From: [Lauren Player](#) on behalf of [Easements&Development](#)
To: [Lander Robinson](#)
Cc: [Natasha Homsey](#); [Easements&Development](#); [Skye.shanahan](#)
Subject: 2020-360 - Hume Battery Energy Storage System (SSD 10460) - Notice of Exhibition (Agencies)
Date: Monday, 31 August 2020 1:11:49 PM
Attachments: [image001.jpg](#)
[HUME BESS - EIS Appendix C - Design Plans.pdf](#)
[HUME BESS - EIS Plan.pdf](#)
[TransGrid Easement Guidelines.pdf](#)
[161214 TransGrid Fencing Guidelines Final.pdf](#)

TG REF: 2020- 360

Proposal: Hume Battery Energy Storage System (BESS).

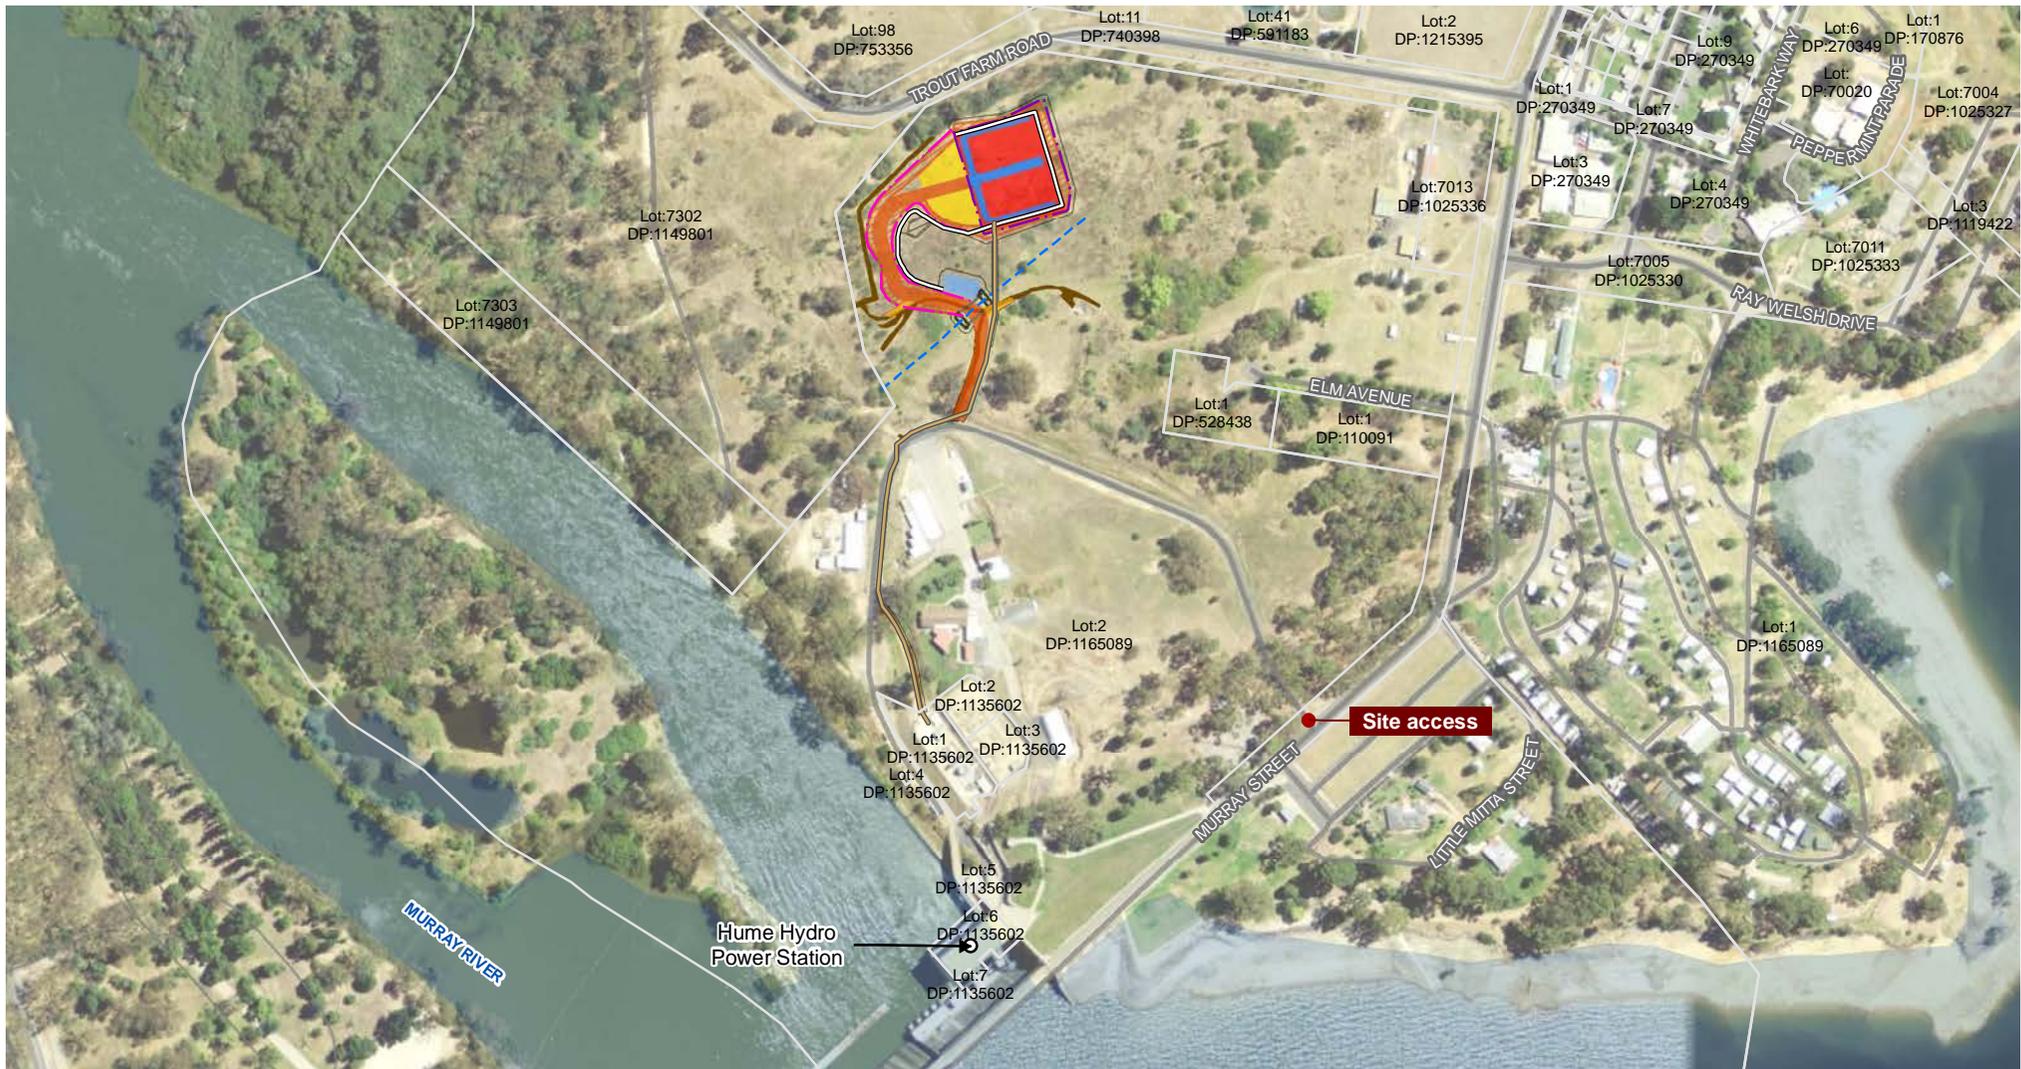
1. TransGrid would like to ensure that the boundary of the Hume BESS facility remains off TransGrid's easement. The EIS shows there is a little bit of overlap between TransGrid's easement of the footprint of the BESS facility land, as per the attached plan taken from page 62 of the EIS.

2. Figure 2-1 does not show the entire length of the proposed underground cable from the BESS to TransGrid's substation. The EIS needs to confirm that the entire length of the cable is included as part of the Project.
